WELWYN HATFIELD COUNCIL – DEVELOPMENT CONTROL
DELEGATED REPORT

APPLICATION No:	S6/2007/1724/MA
------------------------	------------------------

Mymwood House was built as a residential dwelling around 1820 and is a two-storey, detached, white rendered building with a pitched slate roof. Mymwood House has a single storey, flat roofed extension to the rear. The building has been used as a residential care home for the elderly since the mid-1980's and before this had been used as a boarding school from the 1930's. Mymwood house is set back from the highway by approximately 65m. To the front of the site is a detached building Mymwood Lodge. Both Mymwood House and Mymwood Lodge are Grade II Listed Buildings. The site lies within the Metropolitan Green Belt and to the east of the settlement of Brookmans Park.

Drawing Title : Proposed
Sections and Elevations

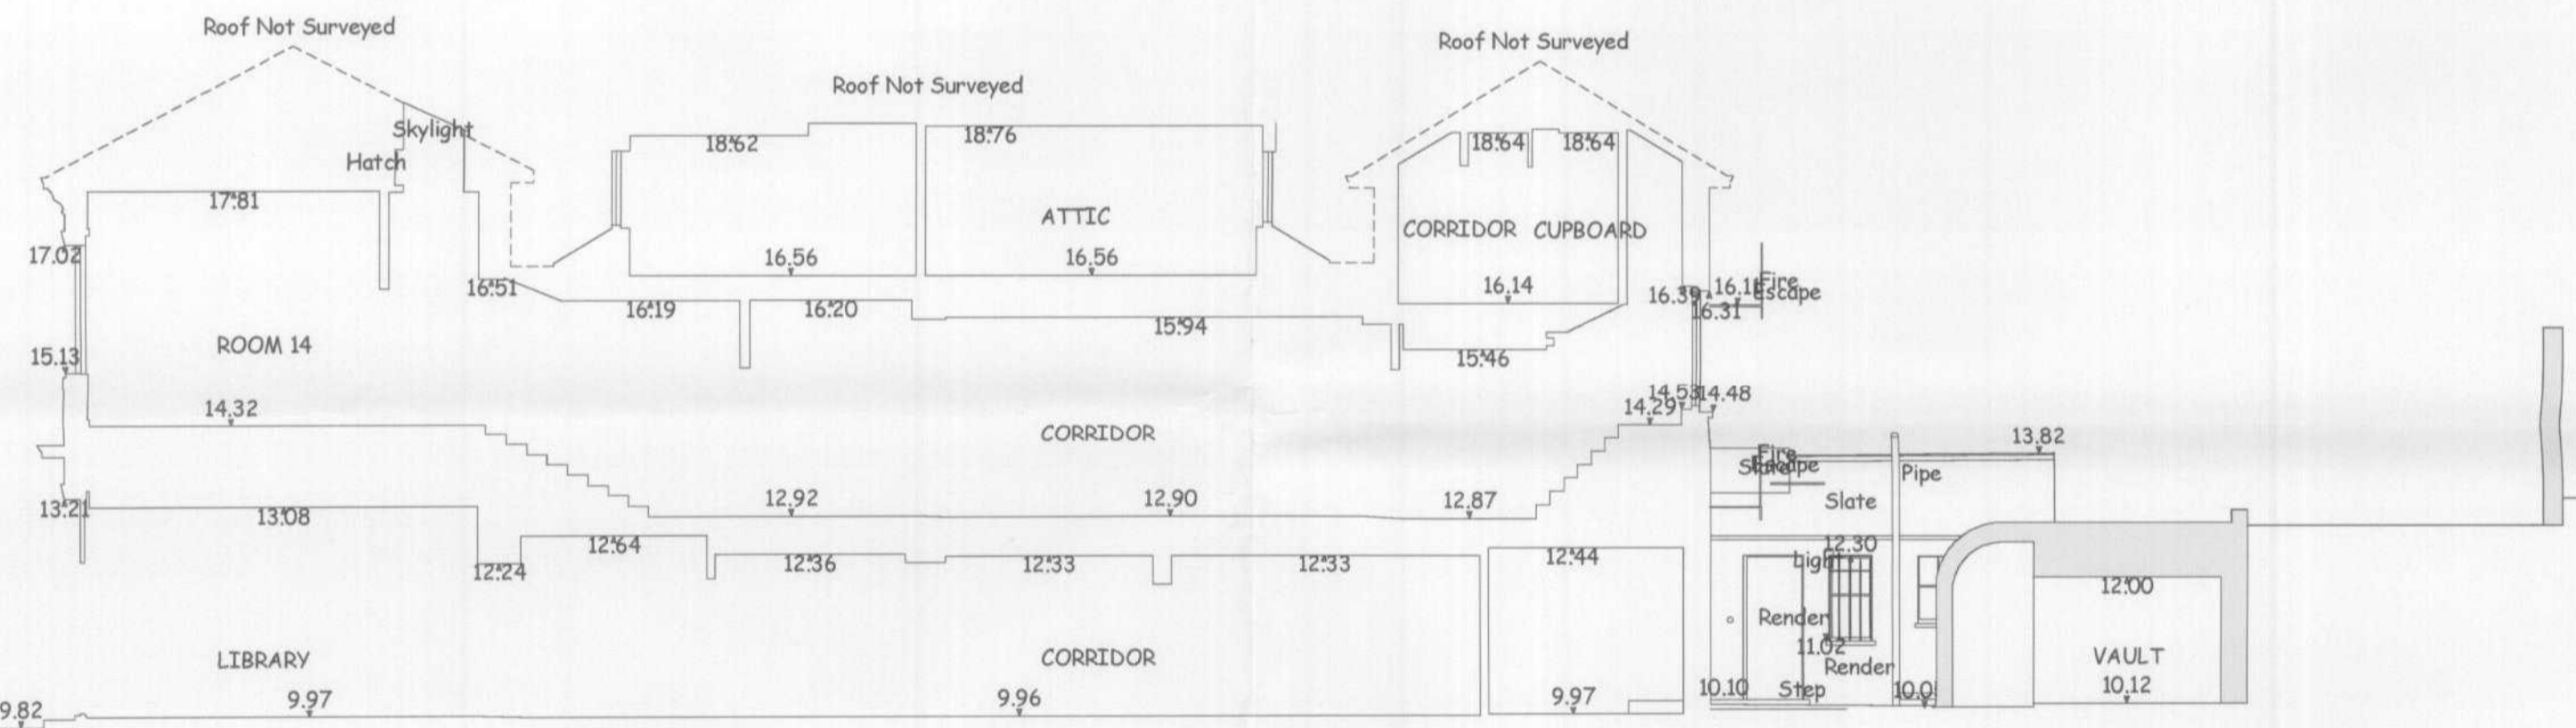
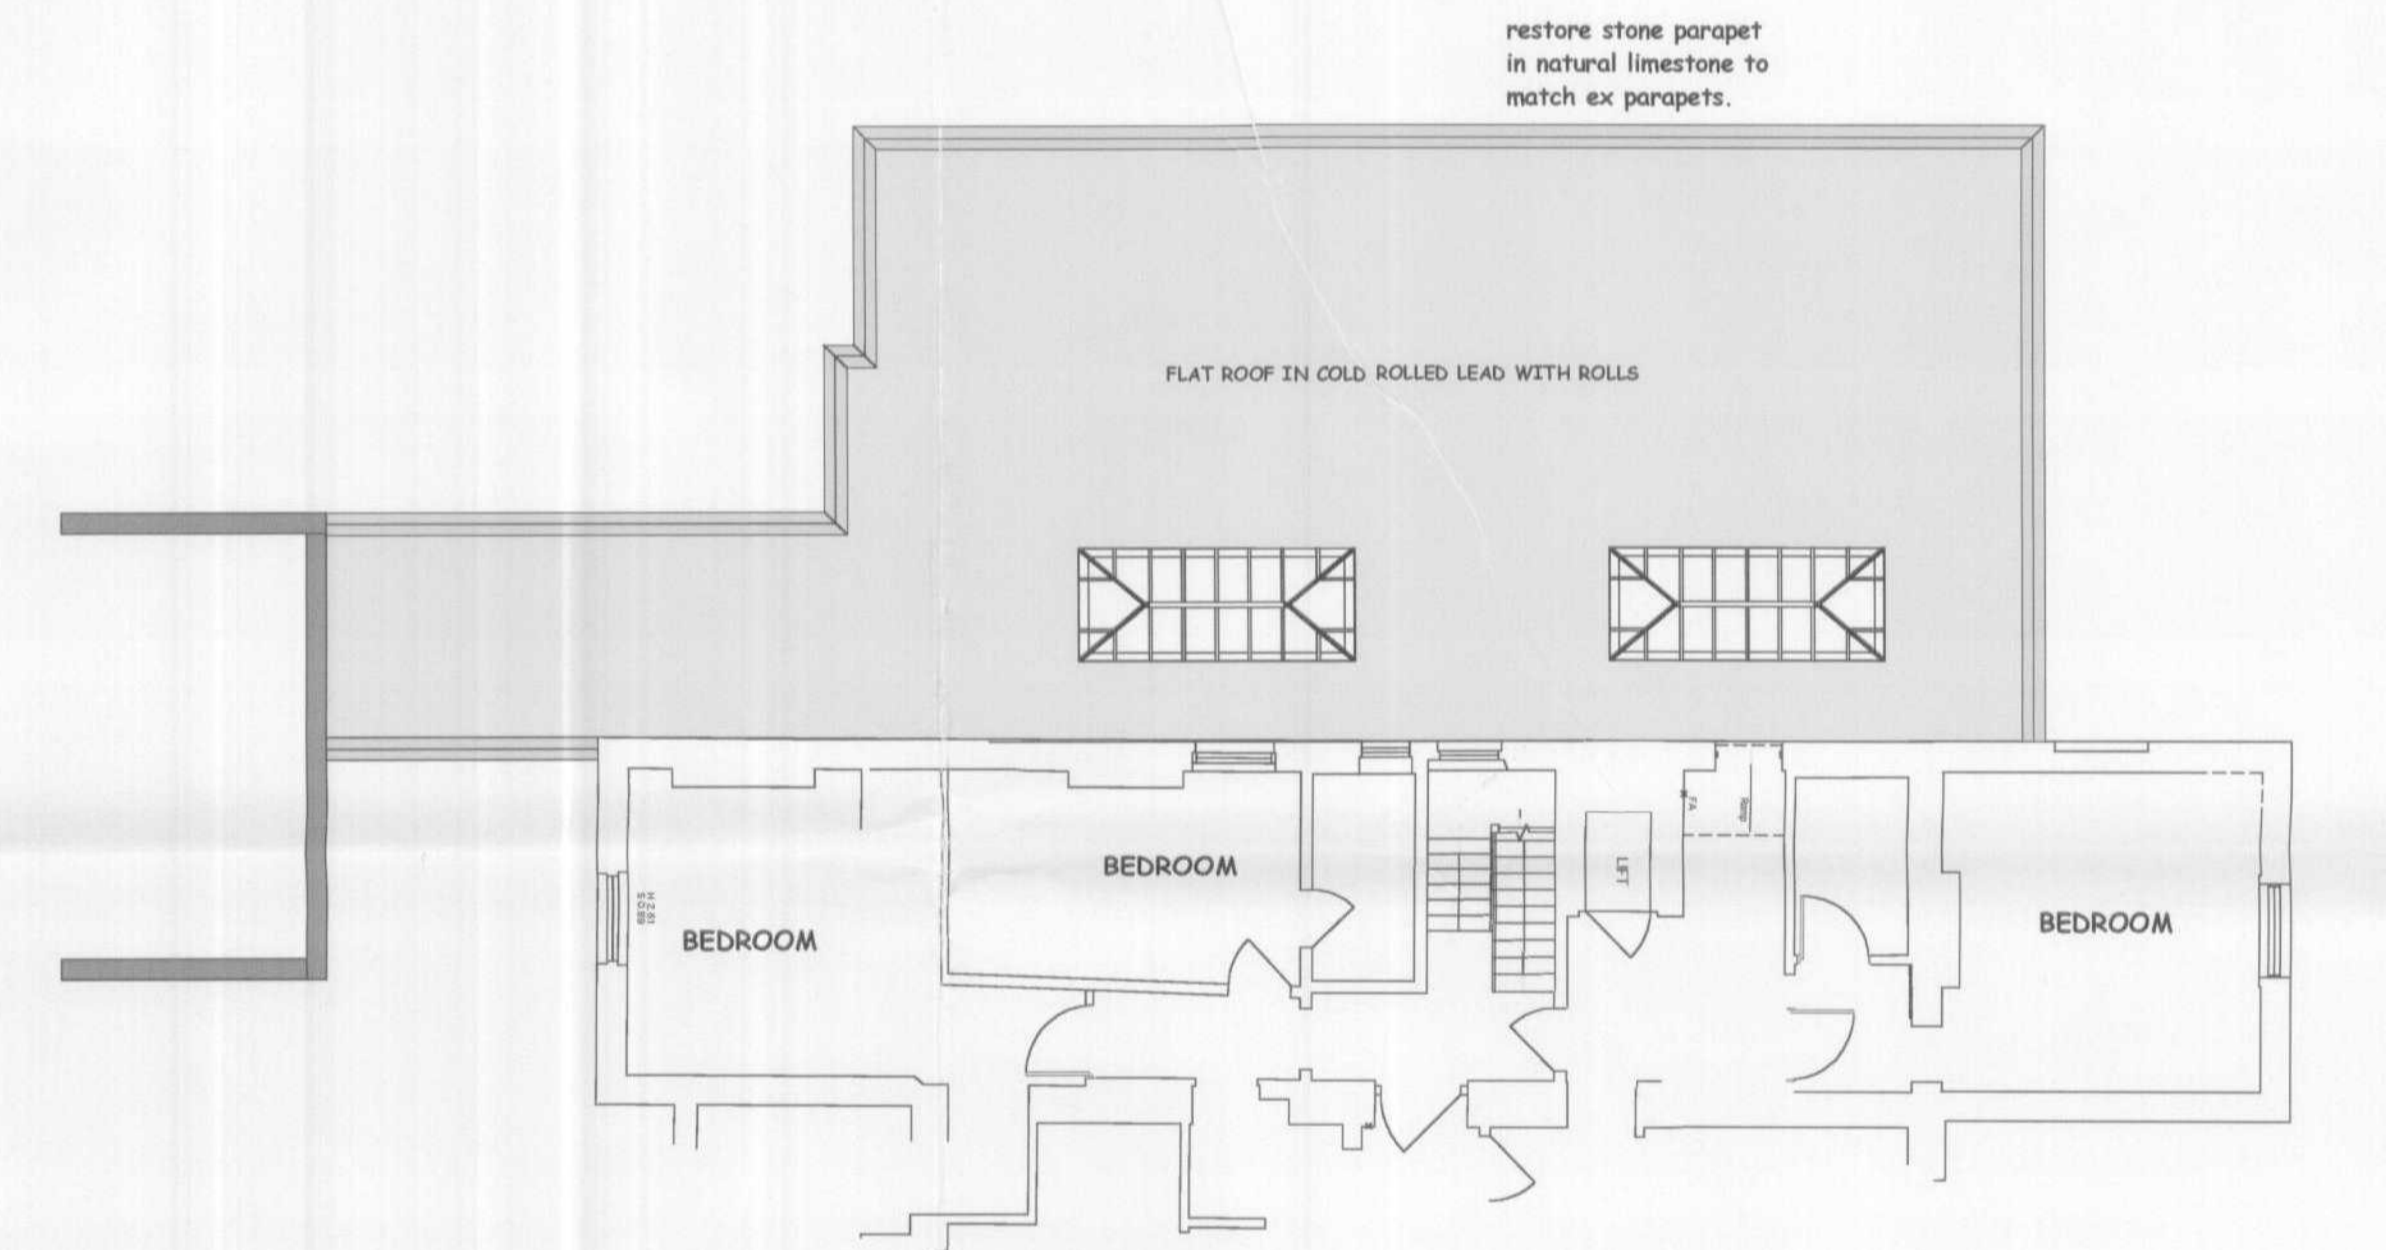
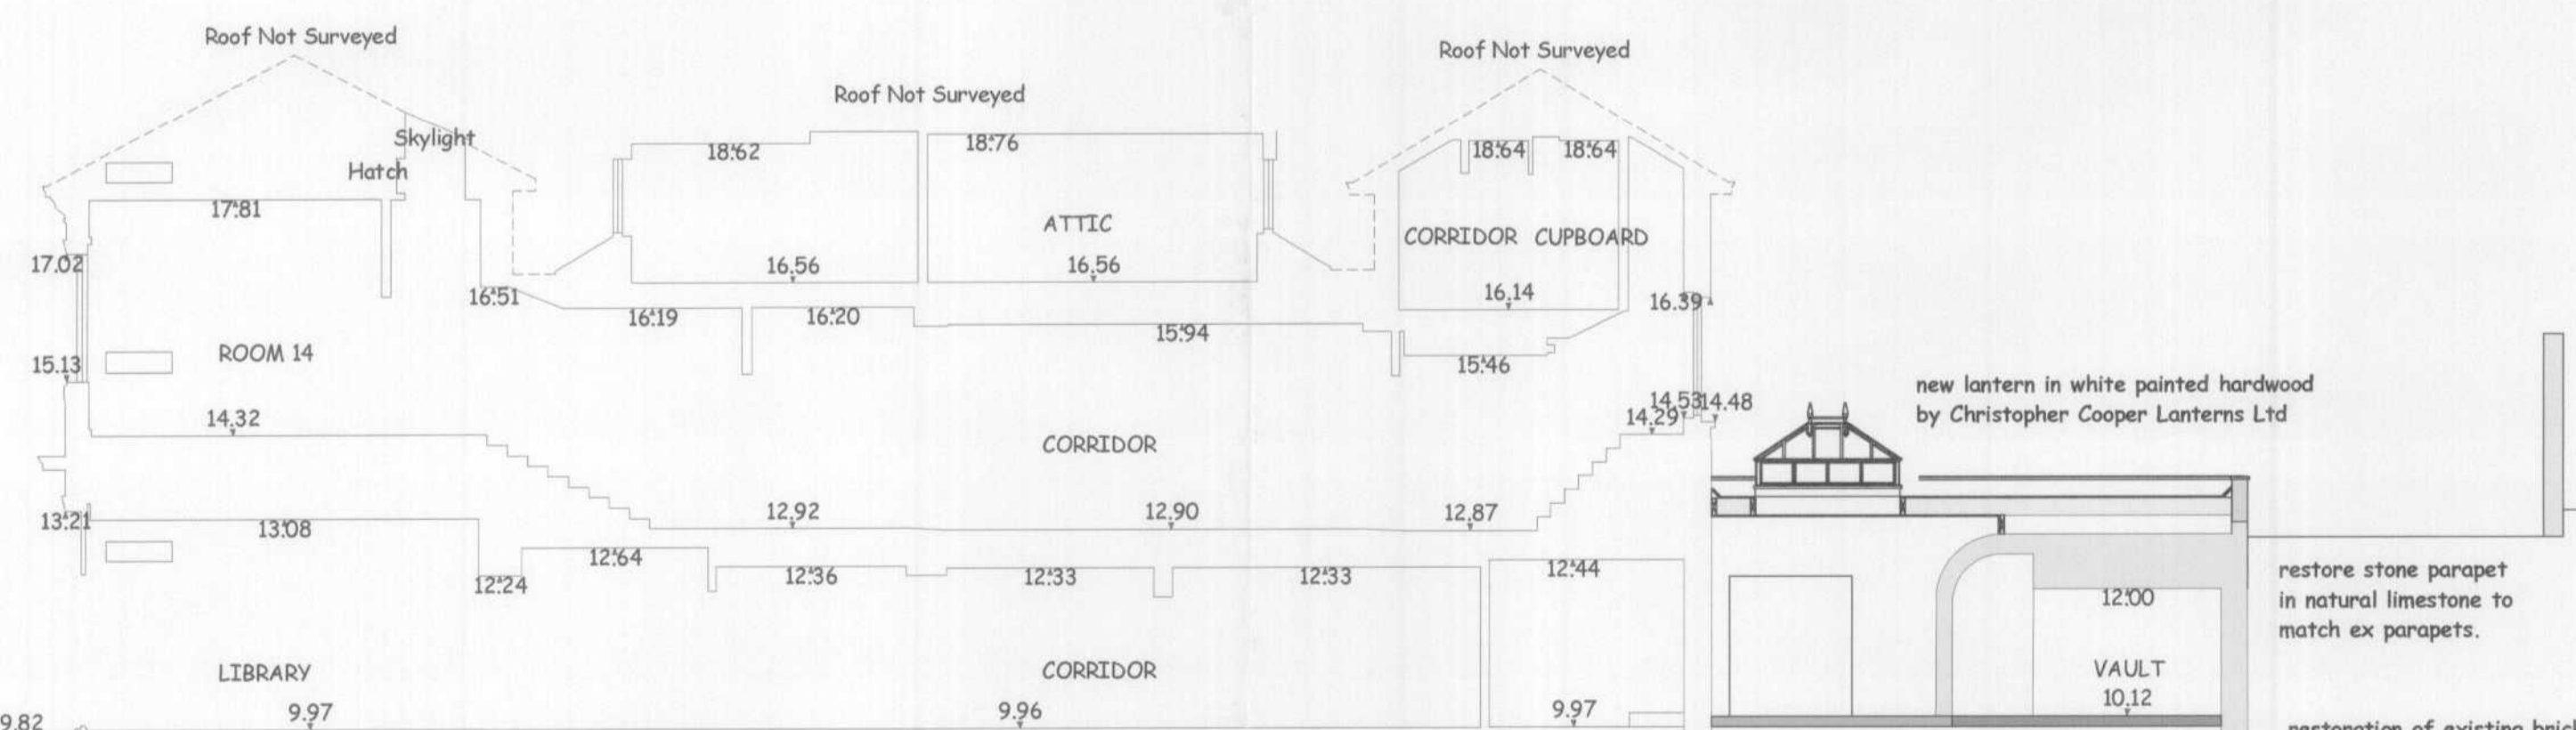
Within the building there is an area which contains 7 vaults which have historic importance. These would be retained with one being converted to be a WC and another being used for storage. The retention of this area is considered to be important and the proposed restoration is considered to be appropriate.
